Pat Quirke-Parry
W 1803/599, Pacific Highway
St Leonards 2065
5th July 2011

Development at 6-16 Atchison Street, St Leonards MP 09 0187

History and Current Concerns.

**Public Domain Atchison Lane Elevation**

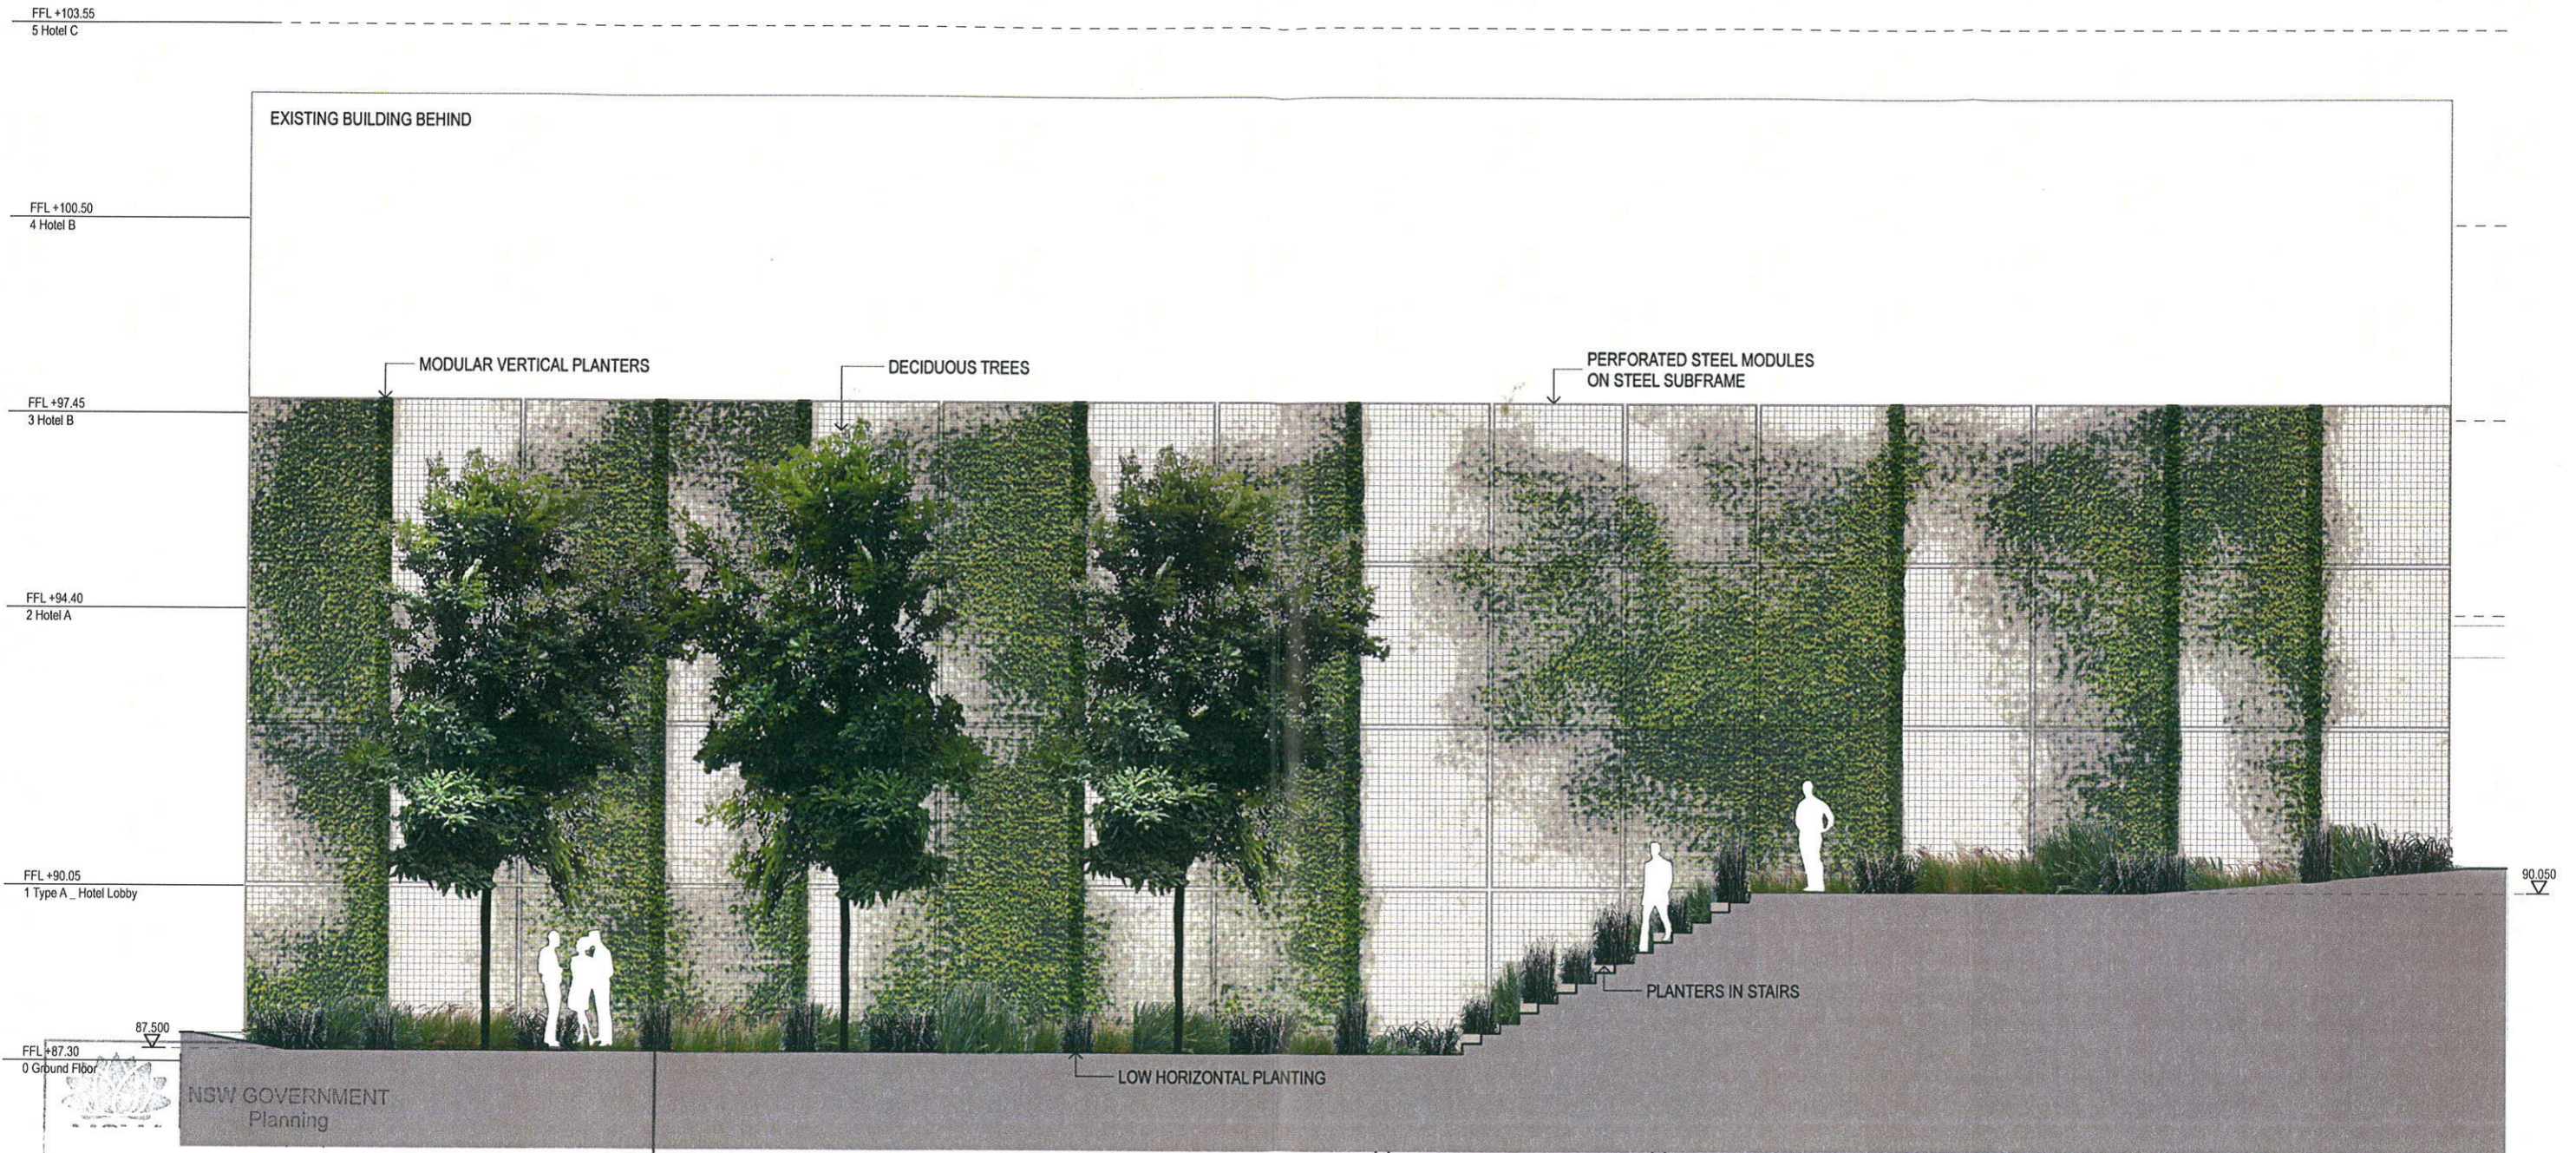
c) We are told in the plan that there will be access to the 6-16 Atchison Street development from Atchison Lane for Garbage trucks, general delivery trucks and LARGE moving trucks. This concept requires the test of common sense. Council trucks will almost certainly refuse to enter this area. Other garbage removal vehicles similarly. LARGE moving trucks require a door height that is unusual and is most often compromised during construction by air-conditioning ducts, wiring etc. which reduce the height of the door disallowing the entry for LARGE trucks. And all the time that these vehicles are trying to enter 6-16 Atchison Streets' loading bay – up to 400 units (multiplied by how every many people live there) will be trying to leave.

Section 3: St Leonards Skyline development with Opportunity Sites– view from north / Chandos Street

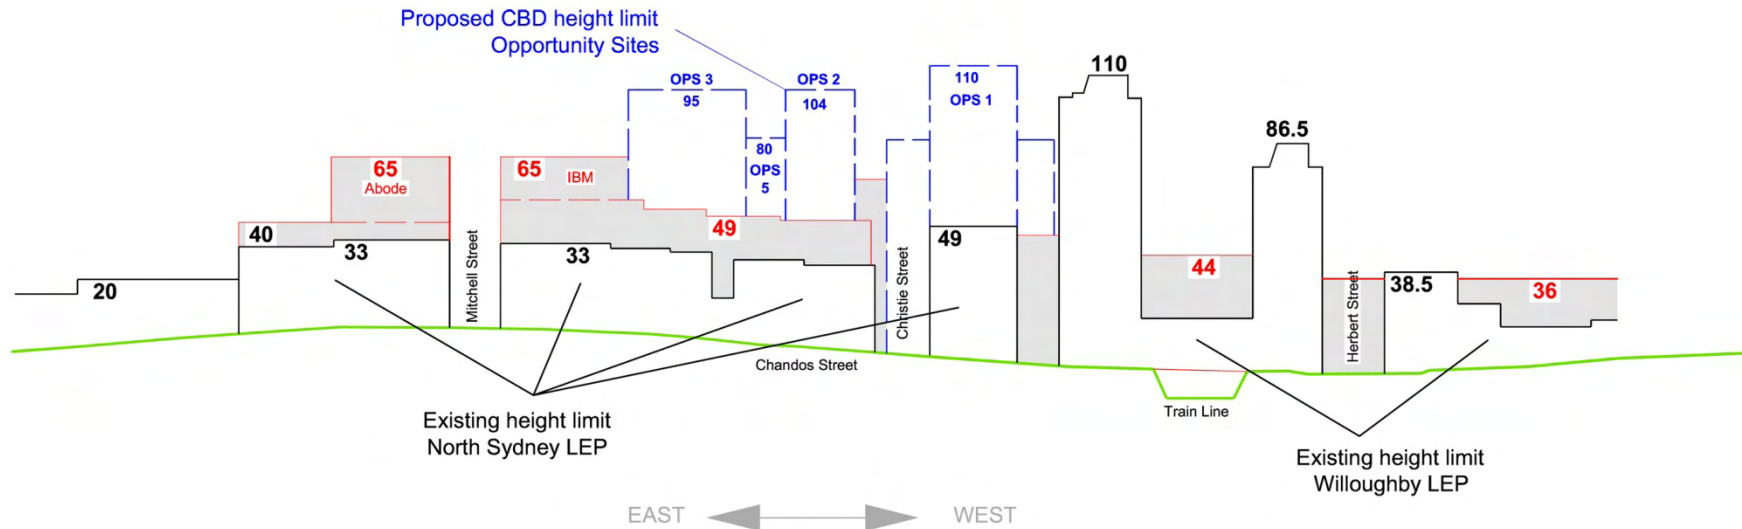
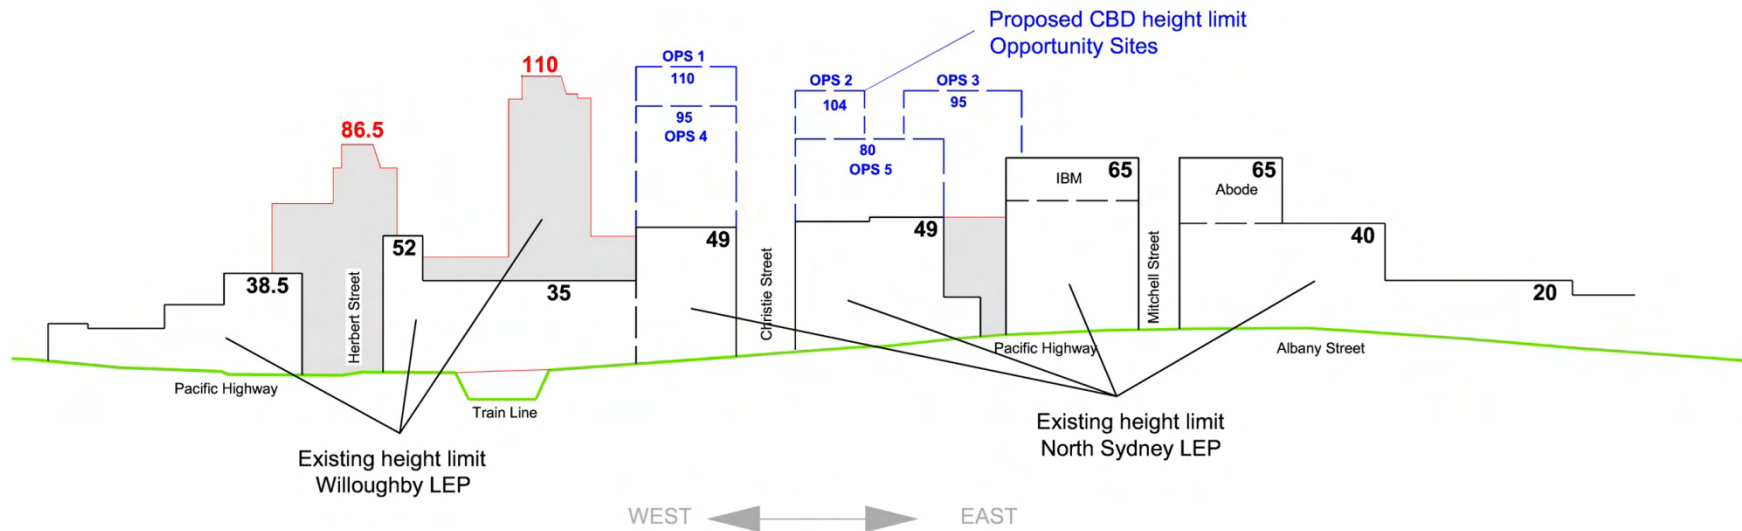
a)The “Skyline Analysis” demonstrates how inappropriate the development is to the immediate environment.
